A46 Newark Bypass

Scheme Number: TR010065

Statement of Common Ground with Nottinghamshire County Council

October 2024

FARNDON UNDERPASS

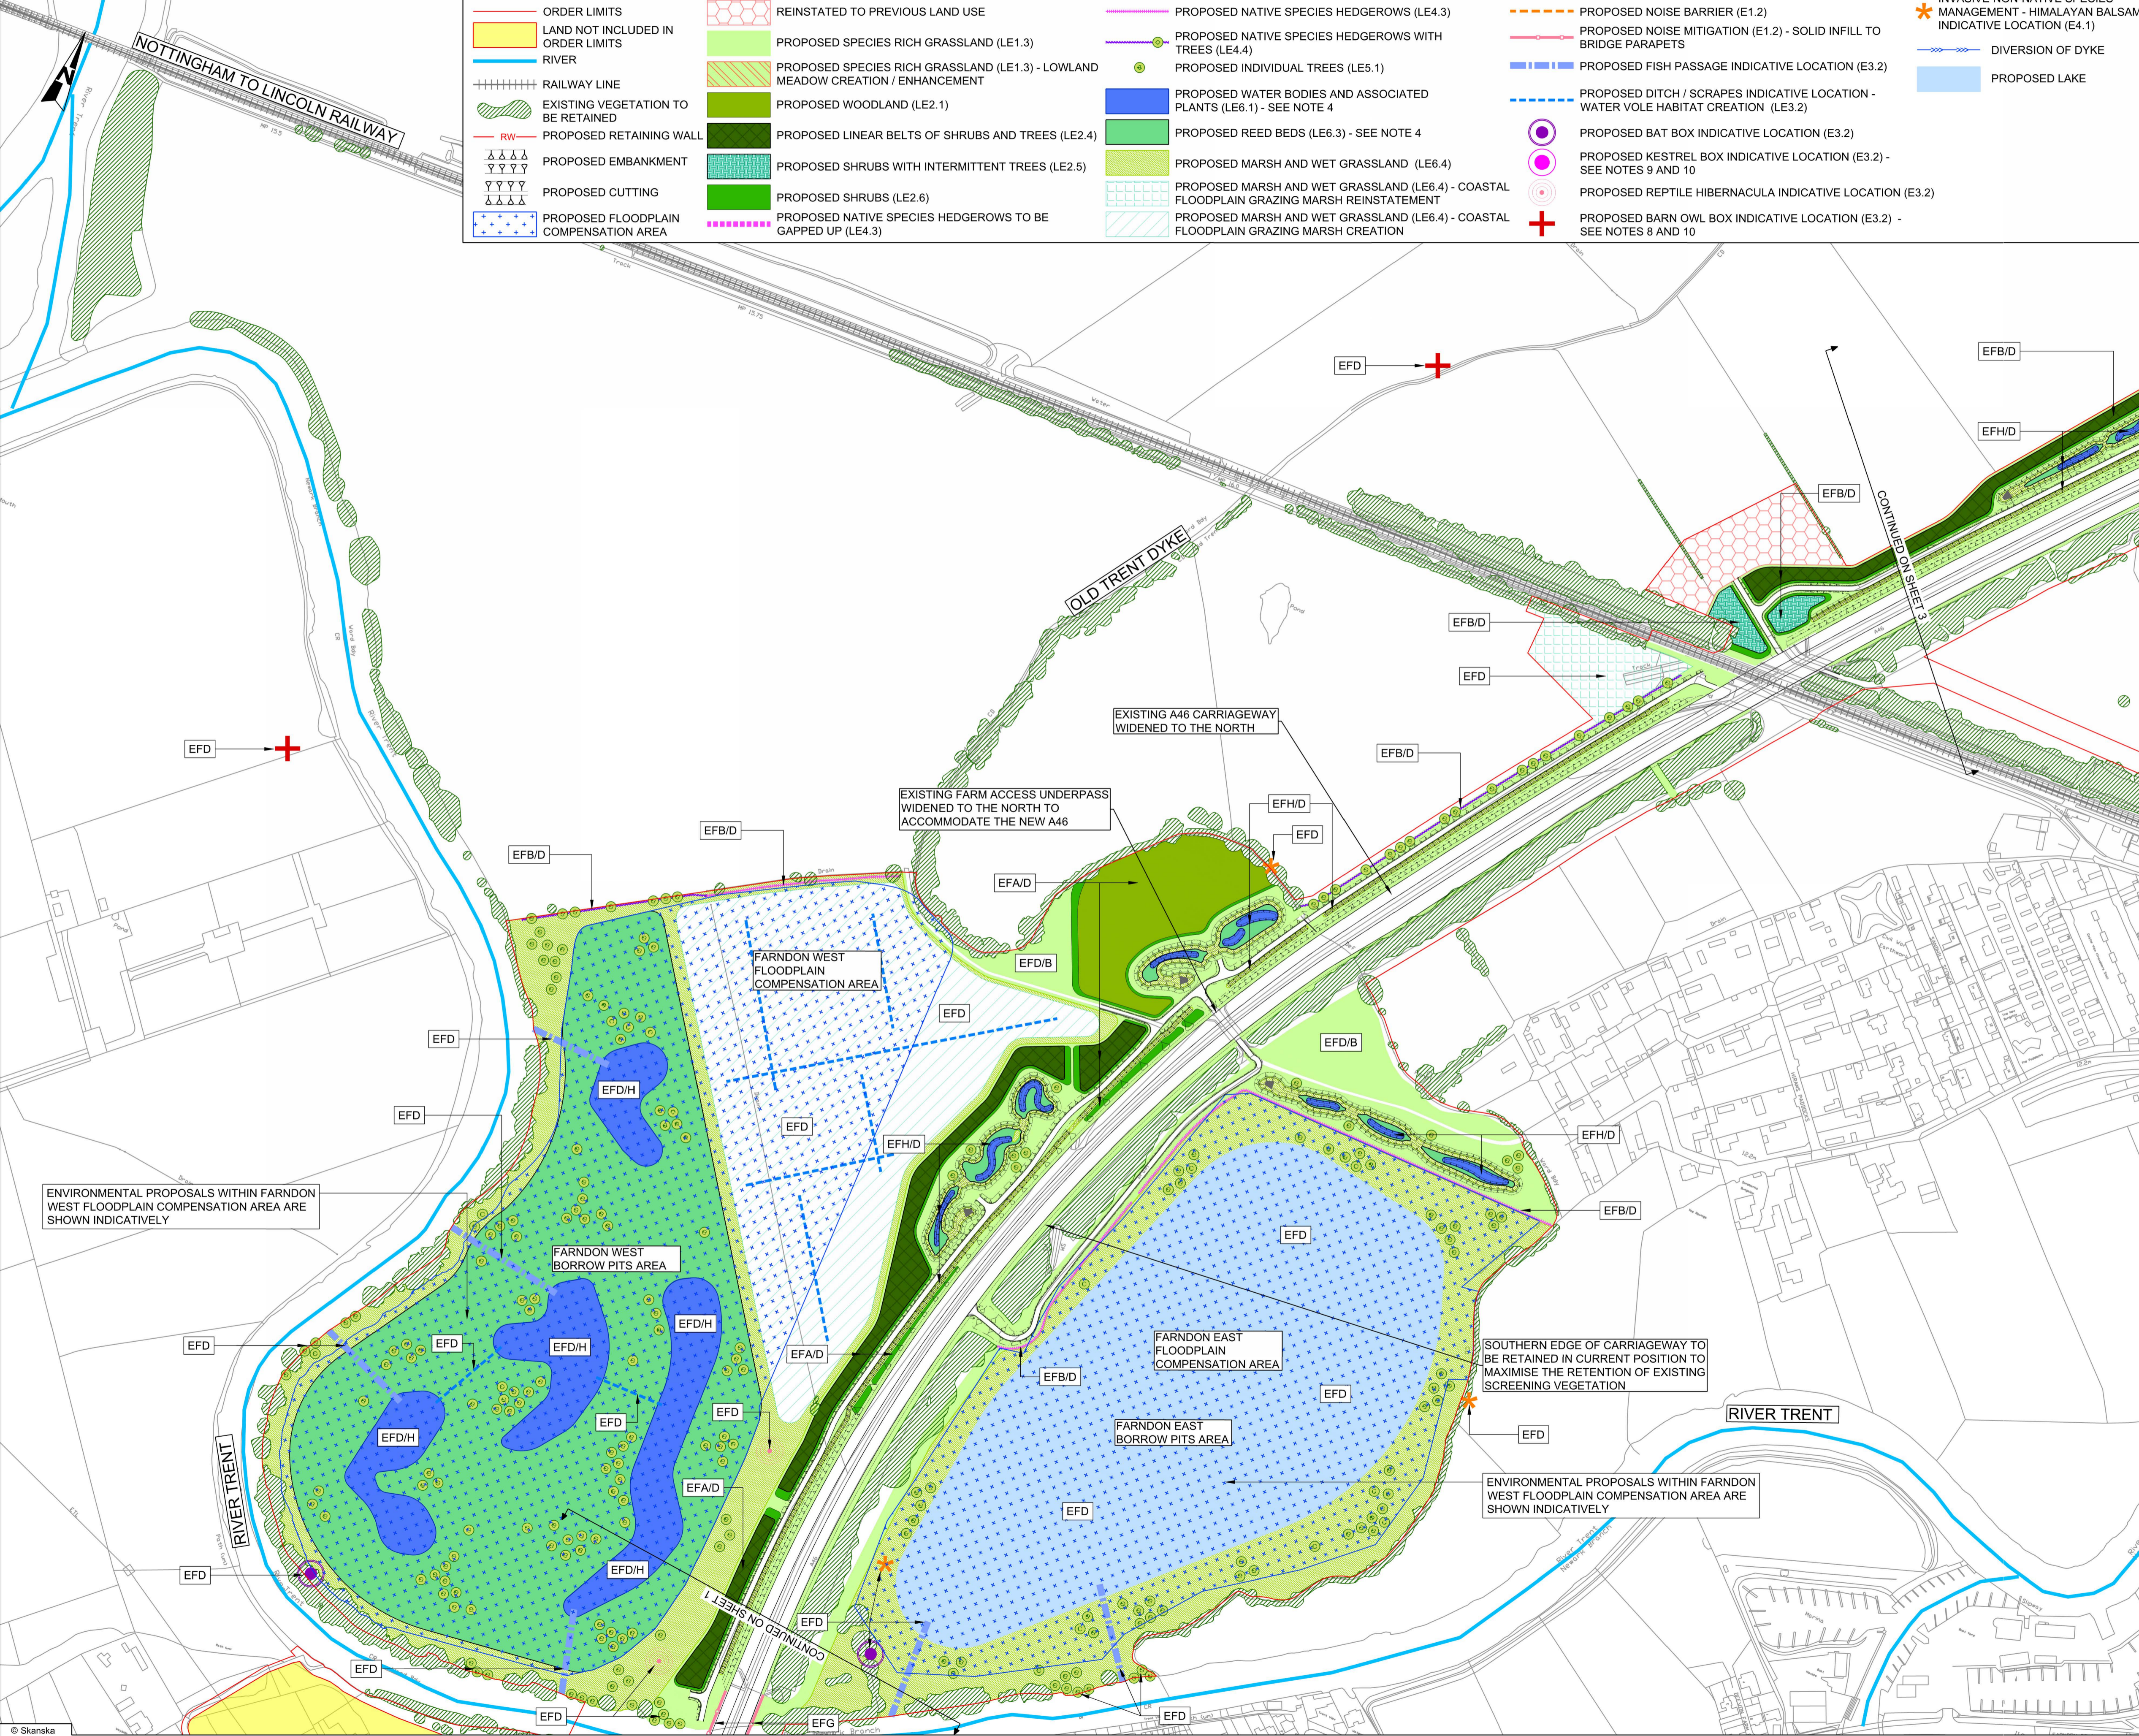
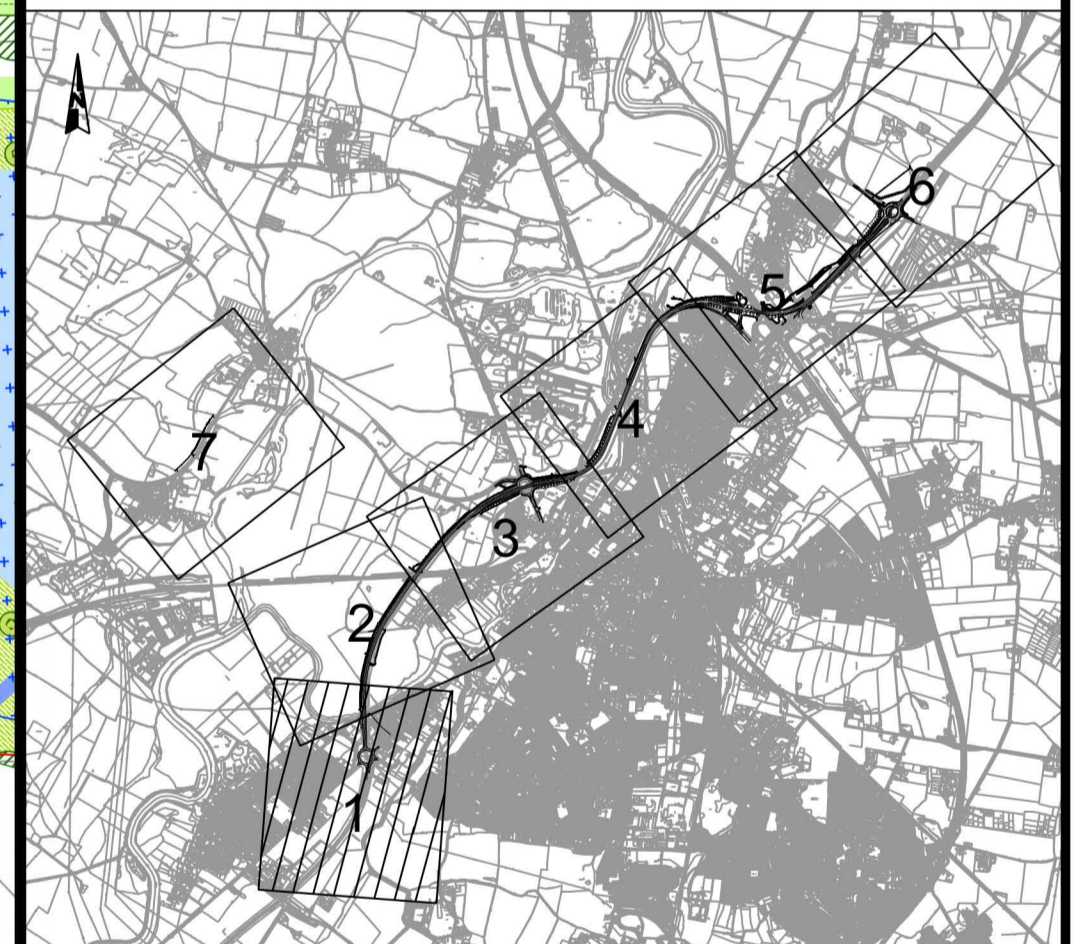
5.	PRoW		<p>Farndon A46 roundabout</p> <p>The plans indicate that the Farndon Underpass will remain open throughout the works which is good. As you are aware the land adjacent to Crees Lane is currently used by members of the public as a walking route, we are also aware that National Highways are planning to use this as a compound. We would support the opportunity to create a public footpath at this location to link the underpass with Footpath No.5 and Bridleway No.2.</p> <p>Farndon A46 roundabout - the land which is set out for the works compound adjacent to Crees Lane has a number of unrecorded desire lines through it. It would be advantageous to see these formally recorded and set out following completion of the Scheme.</p>	<p>Following feedback received as part of the statutory consultation, the temporary diversion of bridleway BW2 was changed, and an alternative route was presented as part of the targeted consultation on the Scheme between 14 March and 16 April 2023. Following further feedback received as part of the targeted consultation the temporary diversion of the bridleway will be only for use by equestrians. Pedestrians and cyclists will utilise the existing footpath FP5 from the River Trent to gain access to the route adjacent to Crees Lane shown within the Order Limits.</p> <p>The unrecorded desire lines are on a piece of land that has been identified for temporary use as part of Scheme, any activity to formally record these desire lines as Public Rights of Way would need to be undertaken by stakeholders, including NCC, outside of the Scheme.</p>	Under Discussion	18/10/2024

**Viewpoint 25: View south from Great North Road (A616) representative of views for road users**

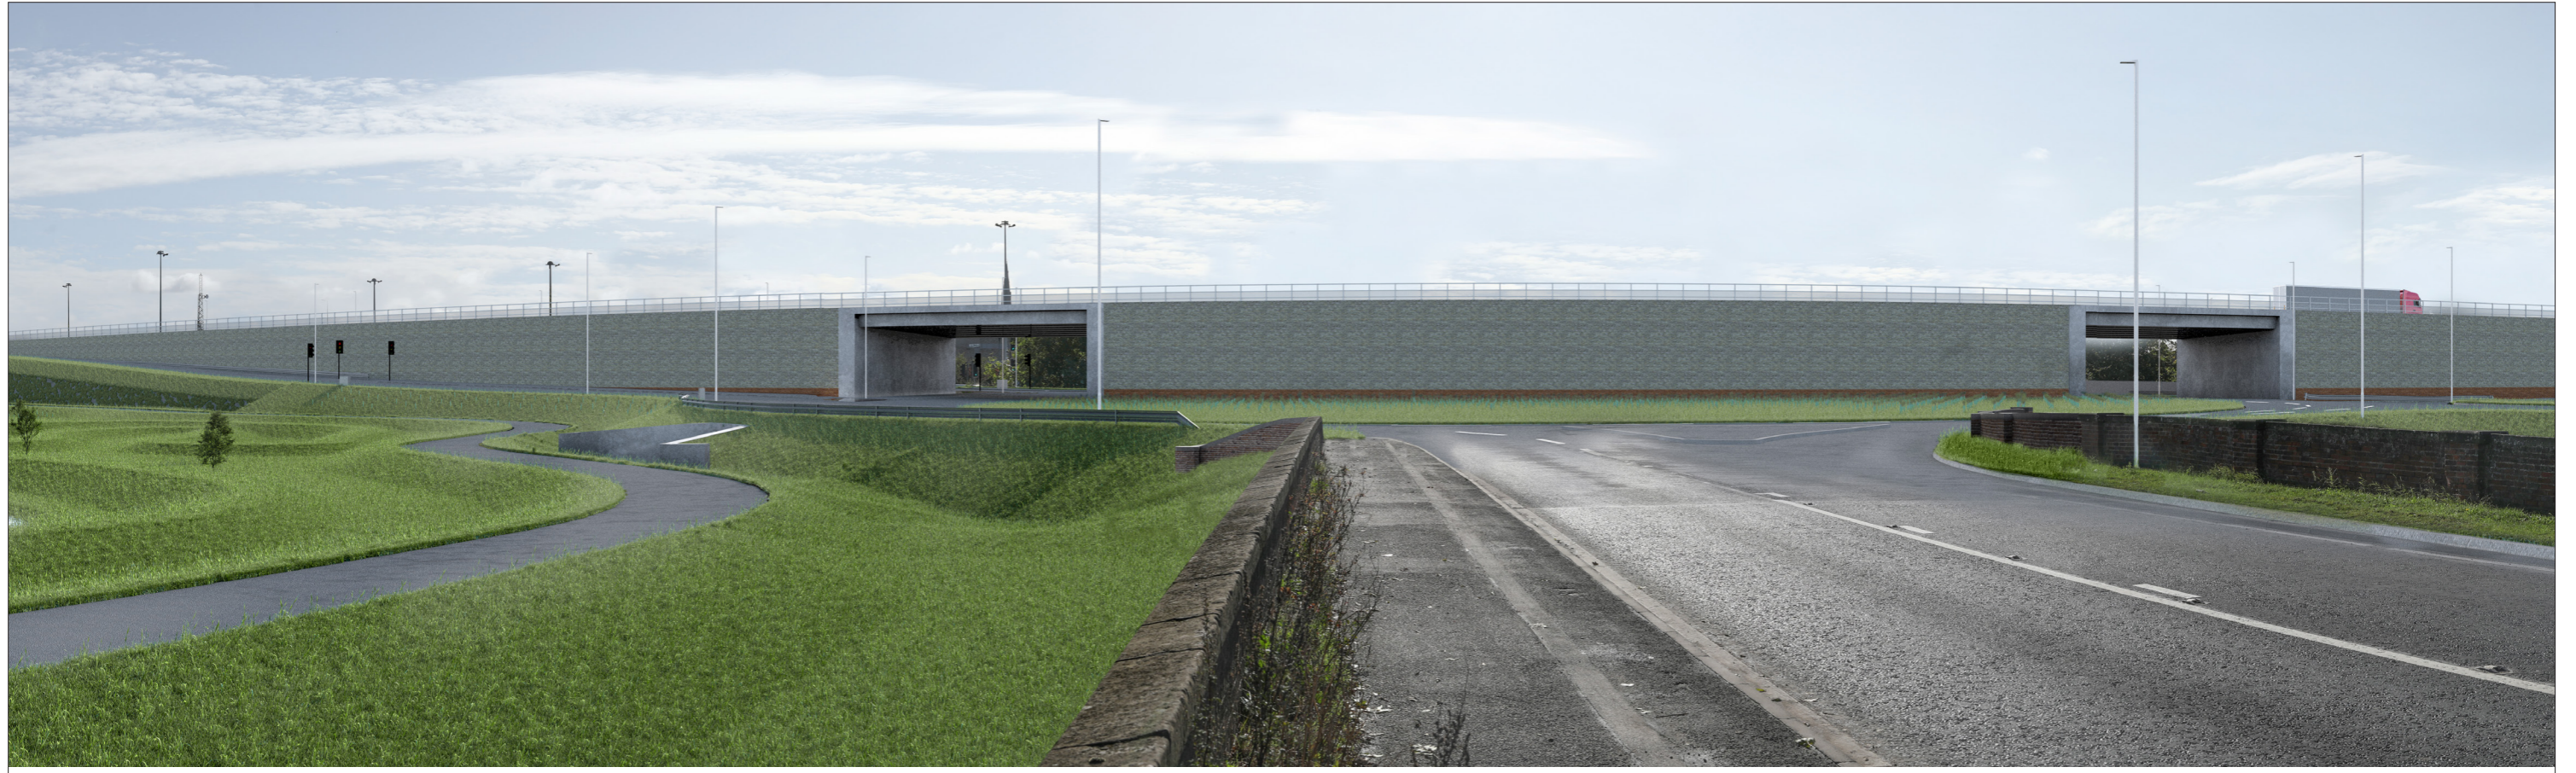
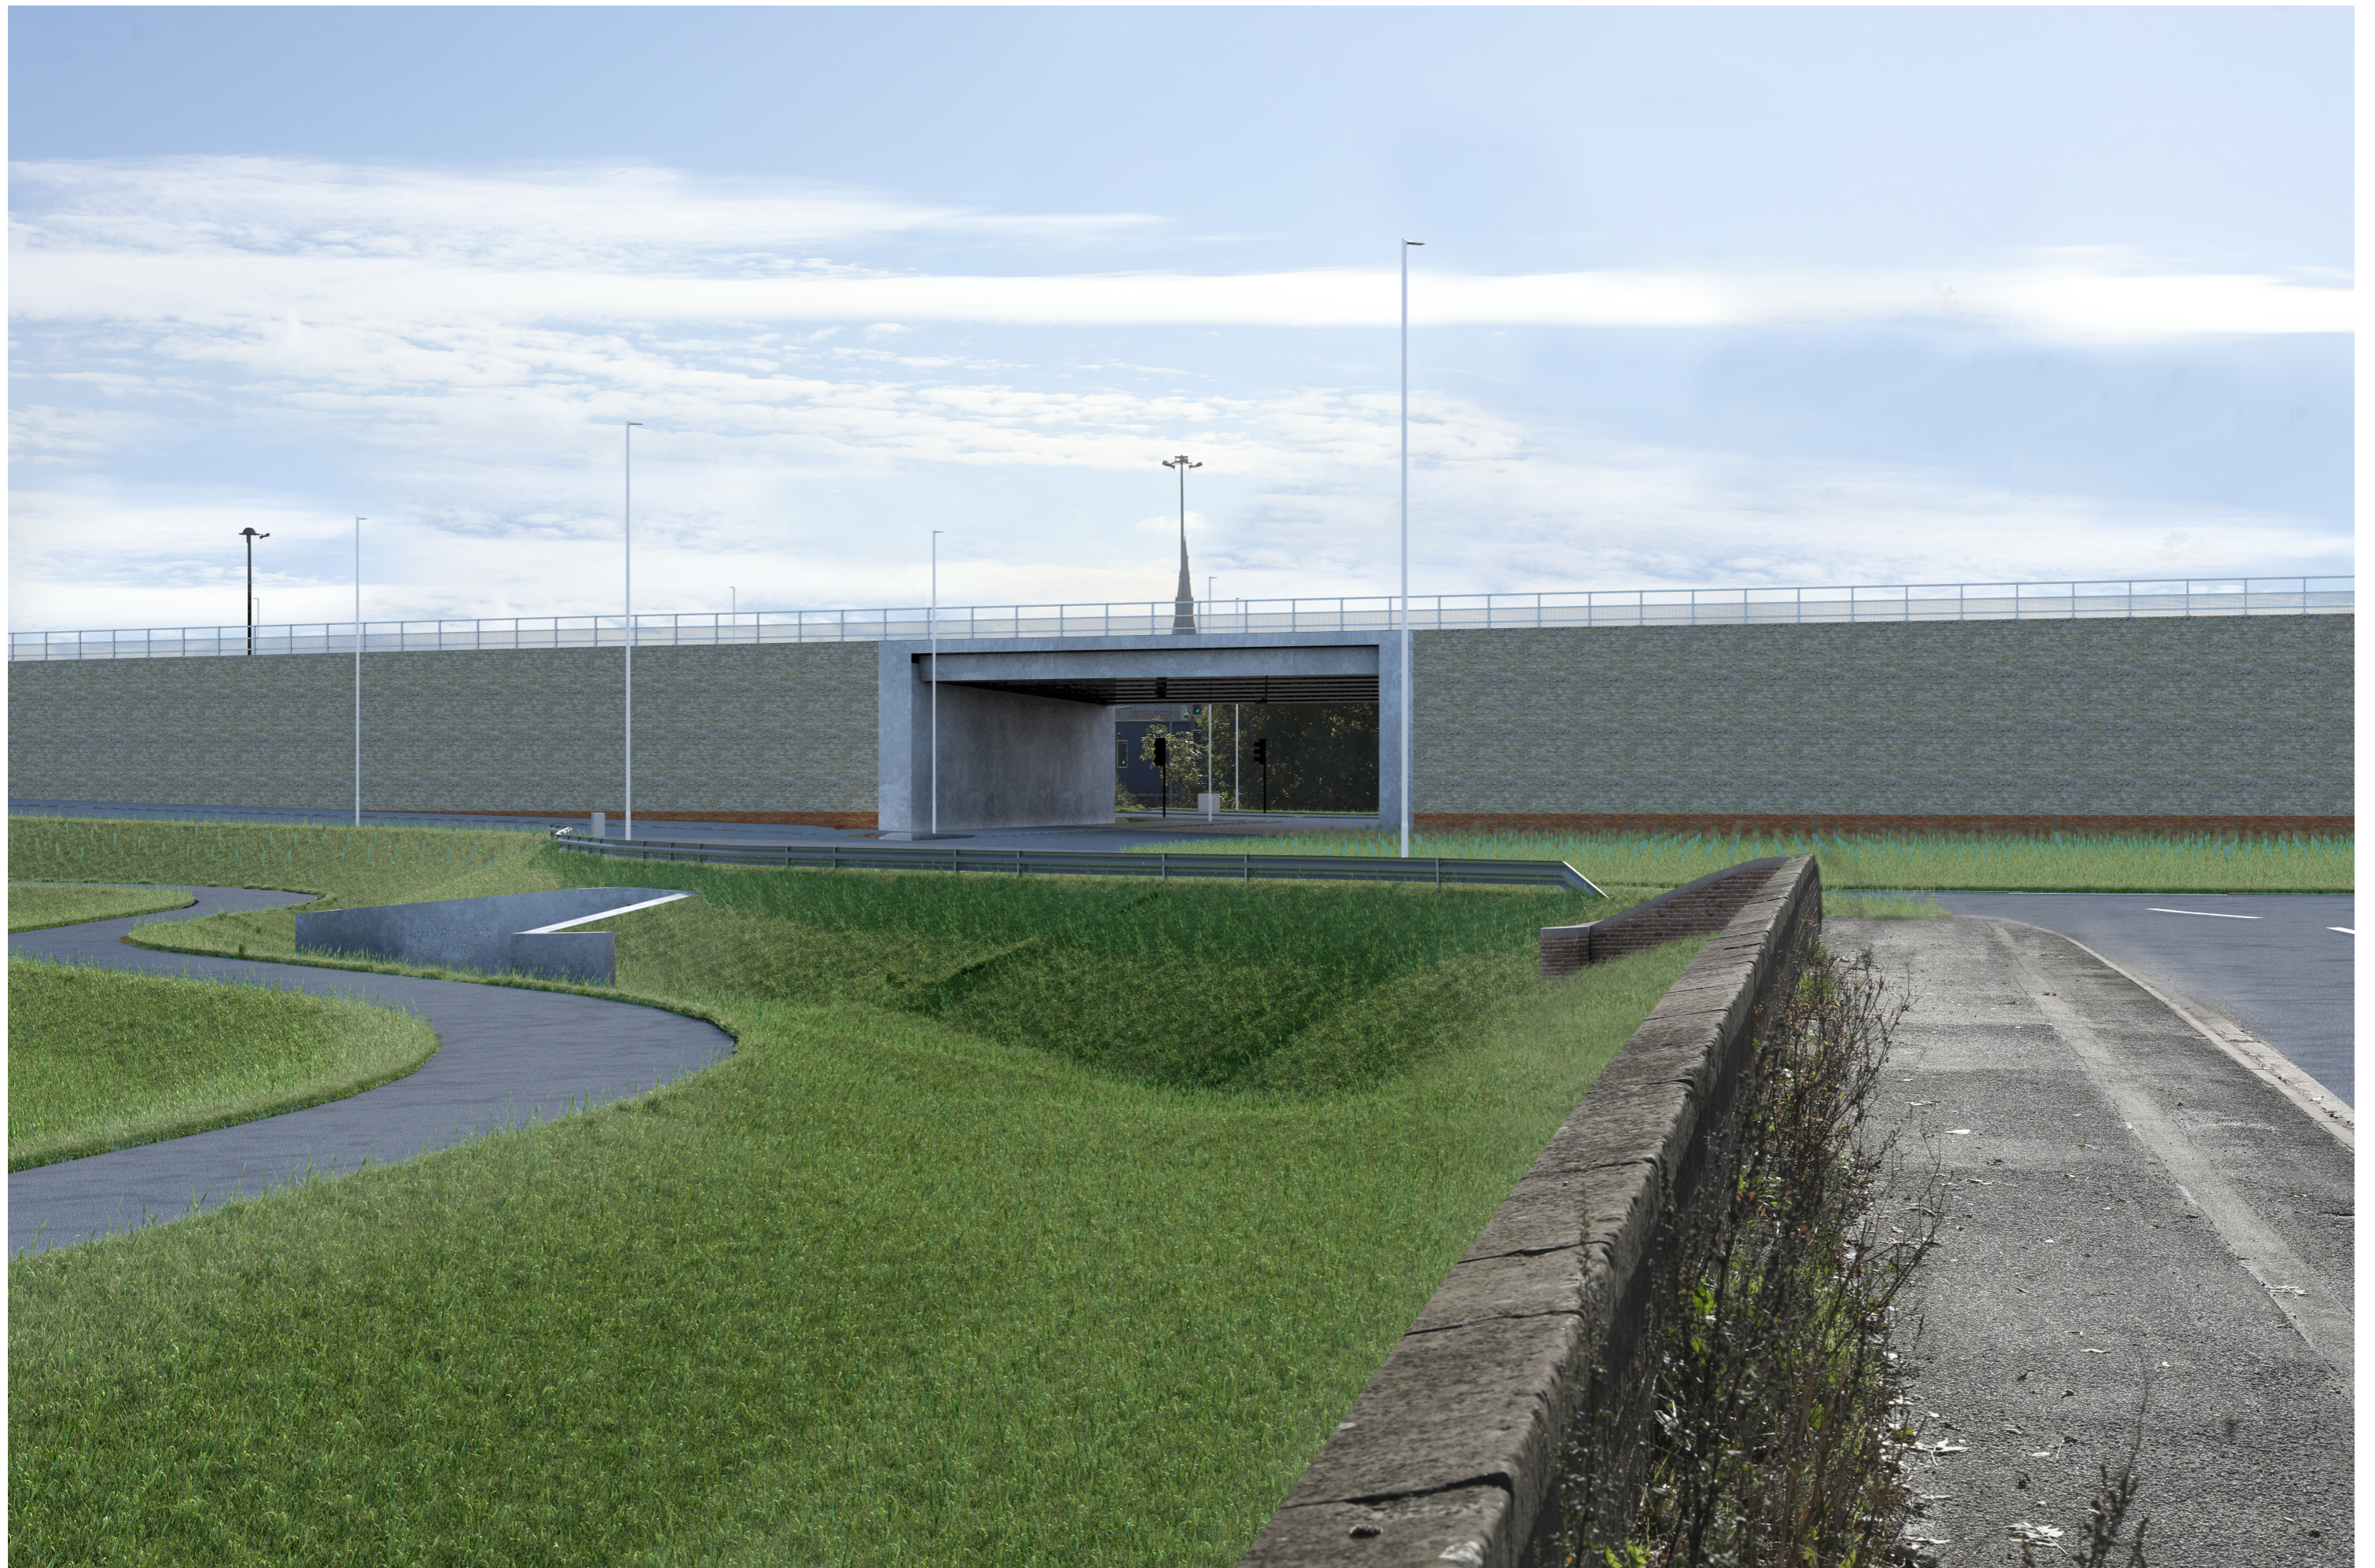
21.	Ecology (biodiversity)		<p><u>Attenuation pond locations</u></p> <p>The Scheme will inevitably lead to the loss of Local Wildlife Site habitat contained within the Great North Road Grasslands LWS 2/778 at the Cattle</p>	<p>Re-locating the basins outside of the Local Wildlife Site would require direct run-off against the natural fall of the land as well as the highway, which in turn would lead to piped runs</p>	Under Discussion	18/10/2024
